Your reference: SSD-71547218

Development Application

**State Significant Development – EIS & DA Exhibition – Waste or resource management facility
8 Styles Street Kurri Kurri NSW 2327, 1//DP1309128**

The RFS has reviewed the bush fire hazard assessment, undertaken in the bush fire report prepared by Cool Burn Pty Ltd (Version 1.1 and dated 12 February 2025) to demonstrate compliance of the proposed works with relevant provisions of Planning for Bush Fire Protection (PBP) 2019.

Residual Material Processing Shed - Ground Floor Plan  
Scale: 1 : 200

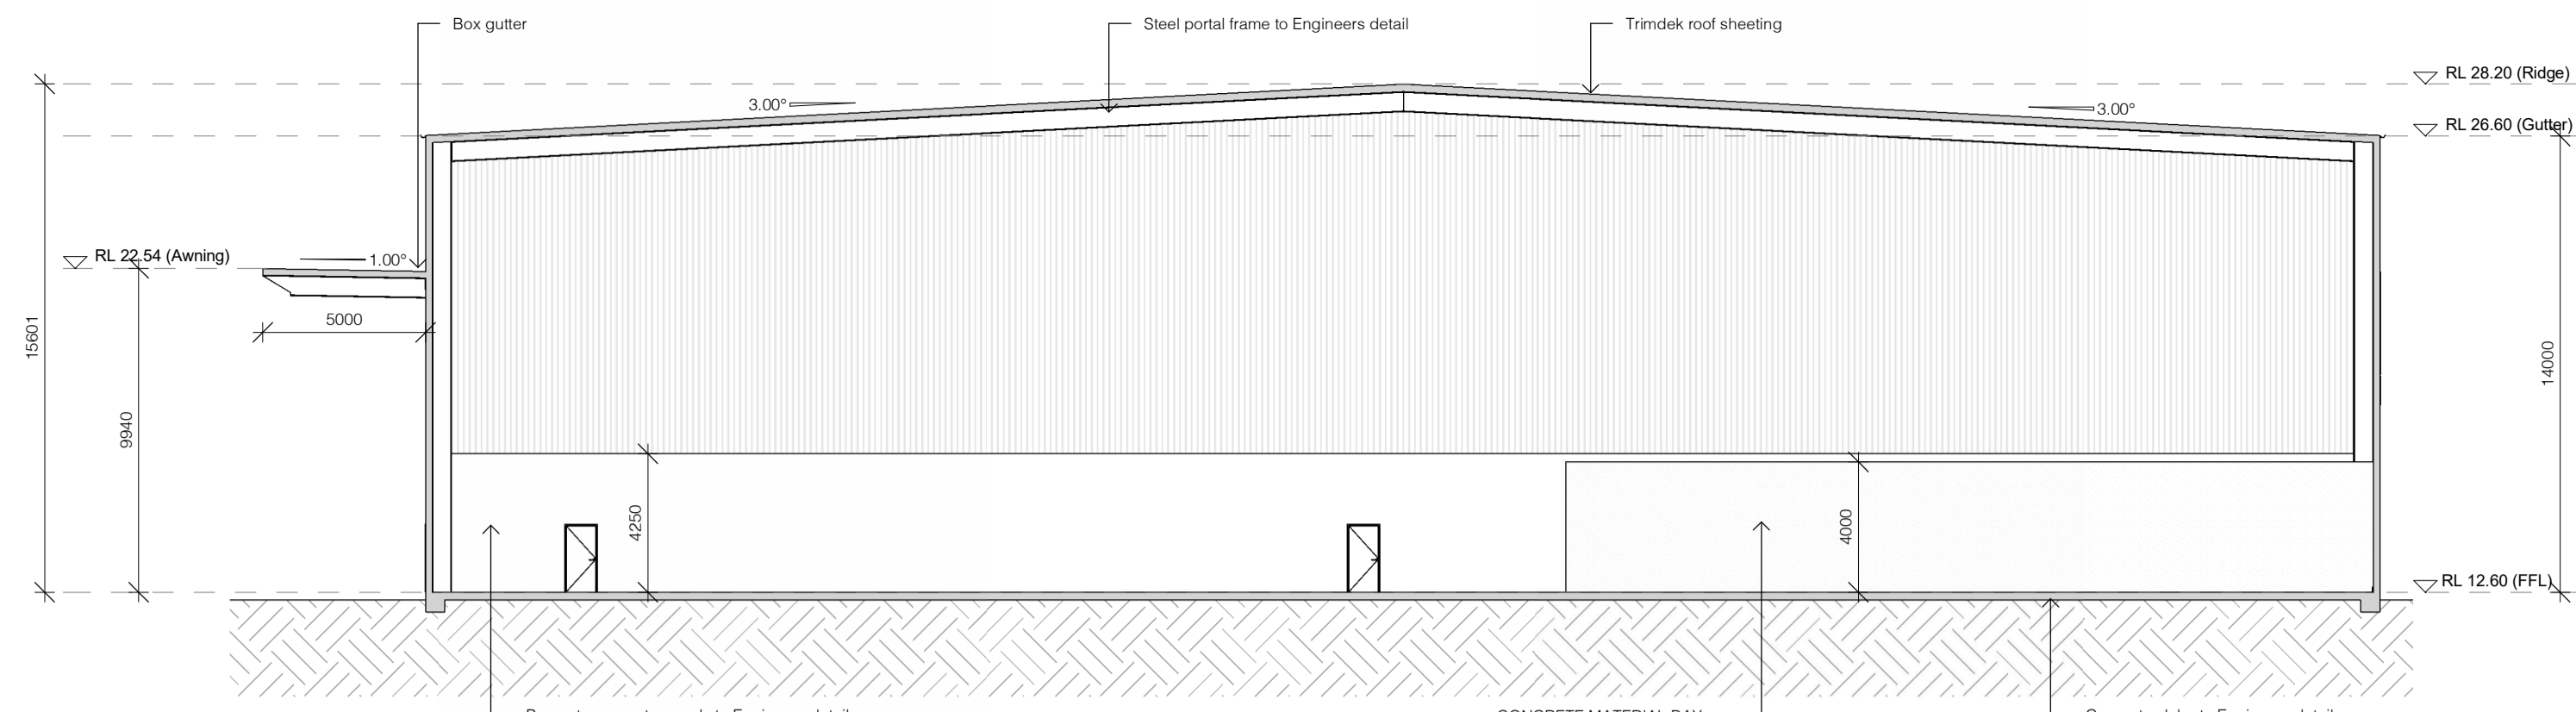
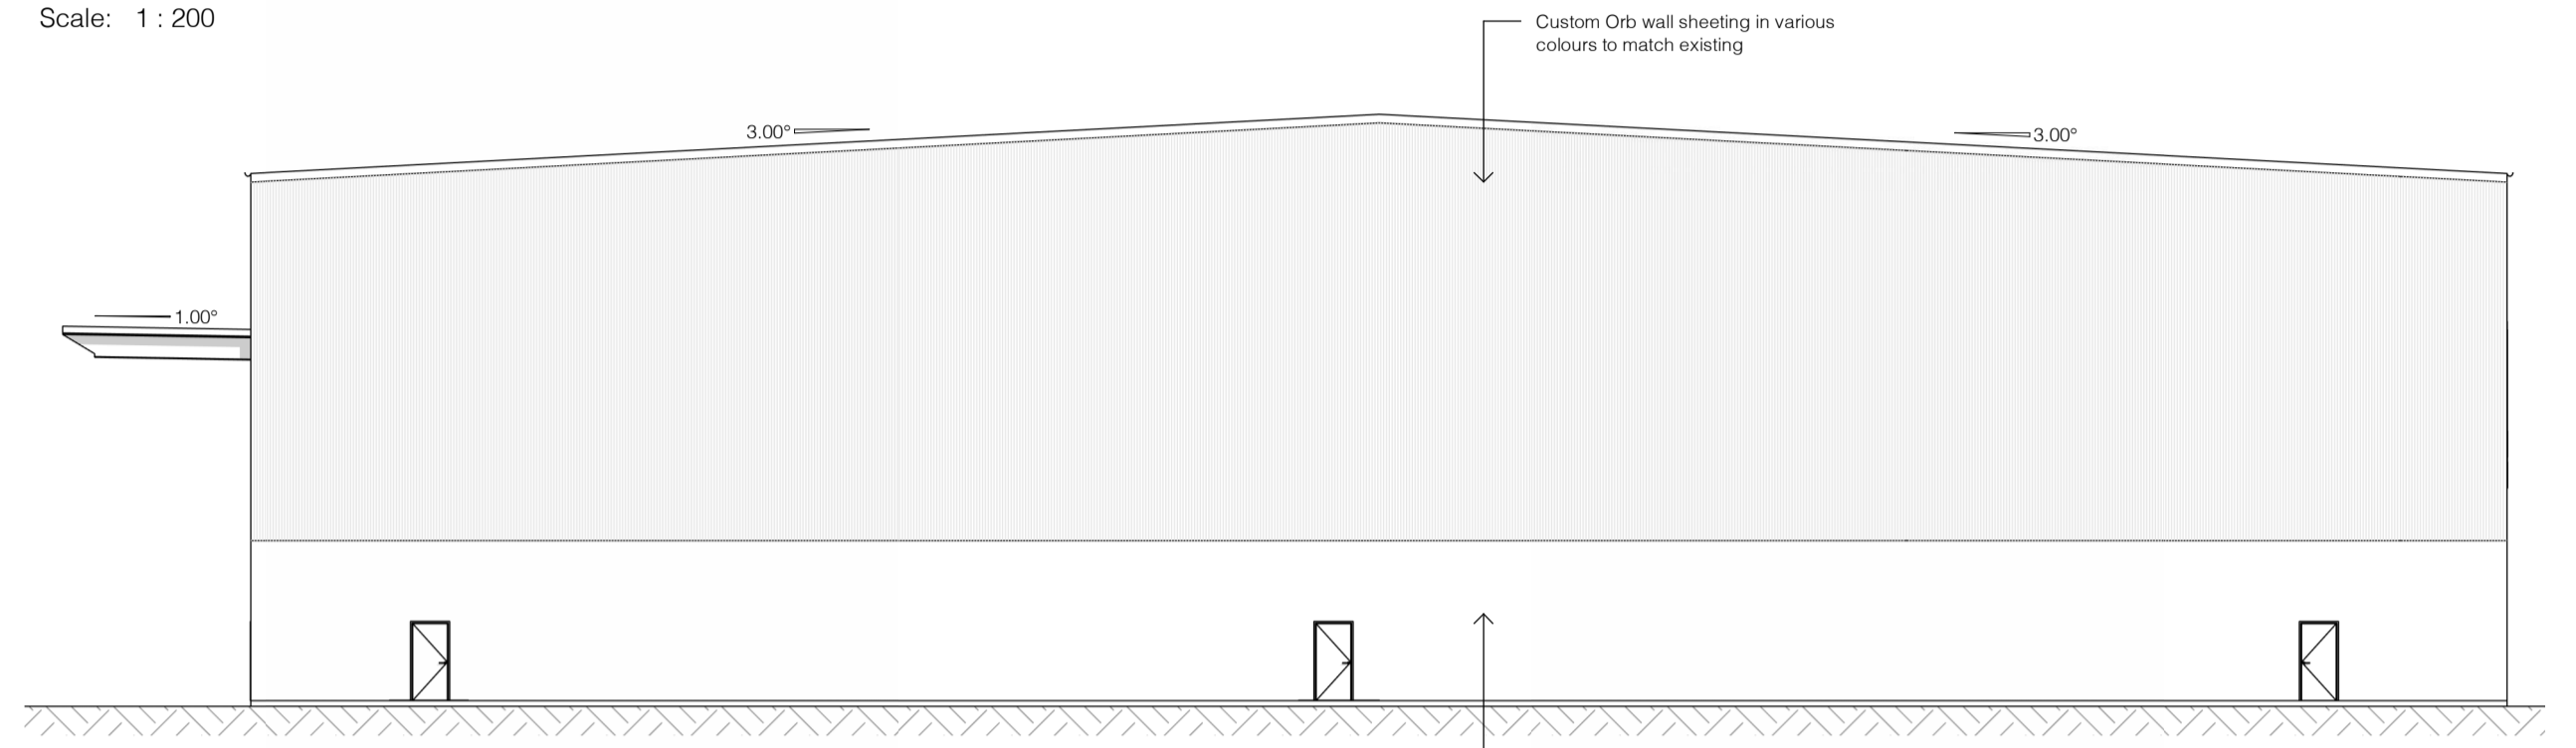
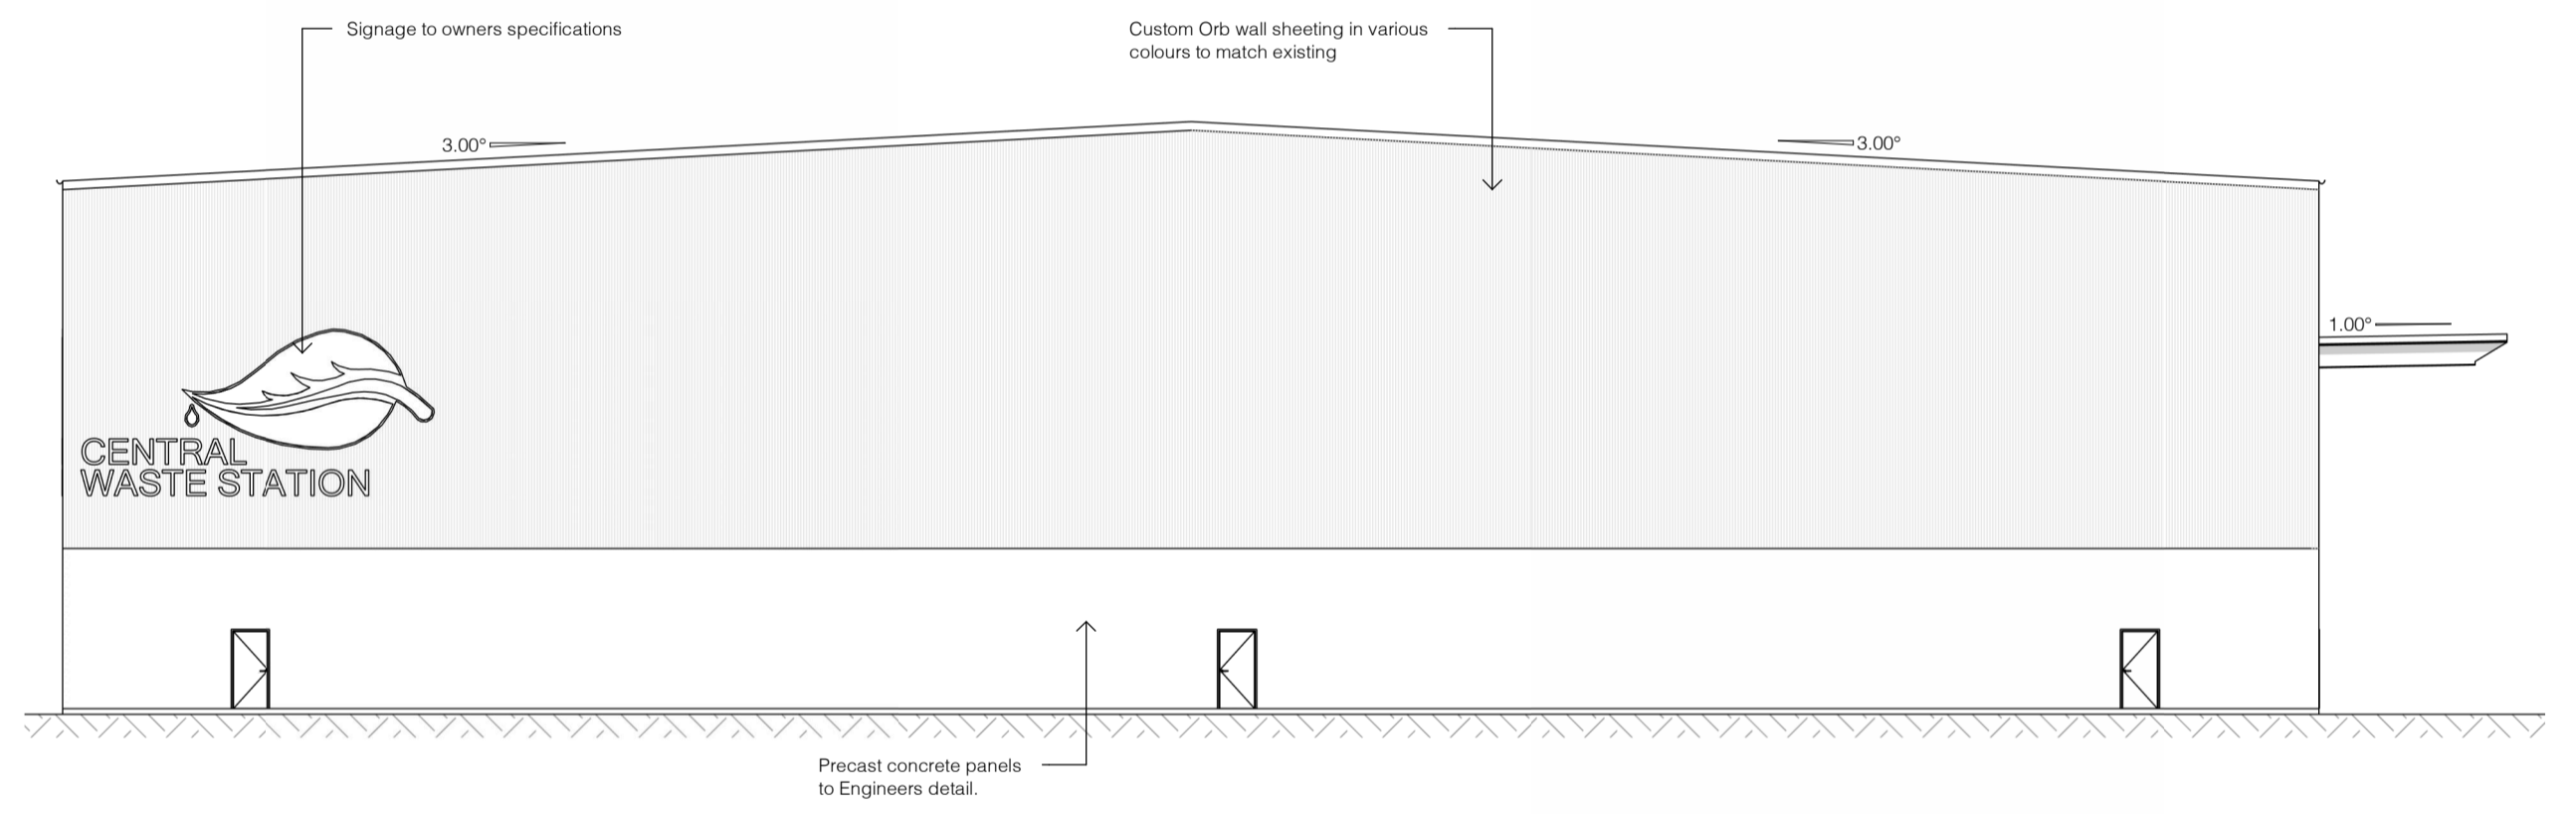
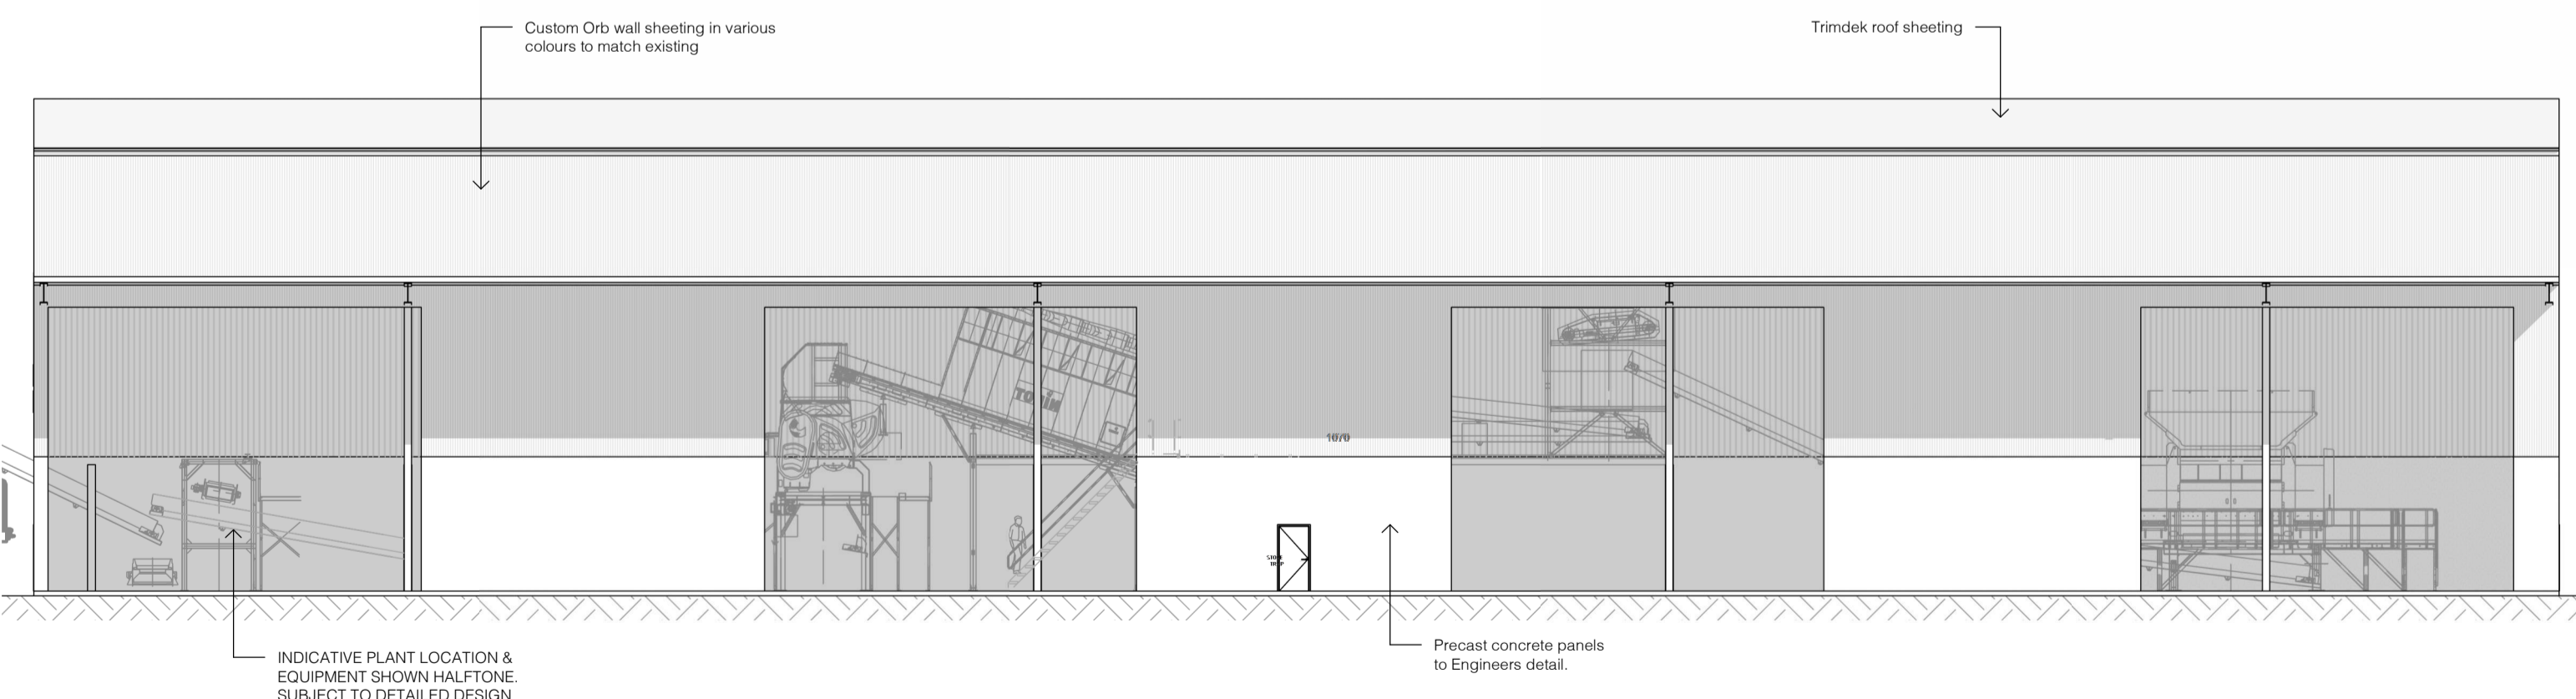
4. Proposed construction of the awnings, located over existing storage sheds, new processing shed additions (material bays) and the residual materials processing shed, must be undertaken using non-combustible materials.
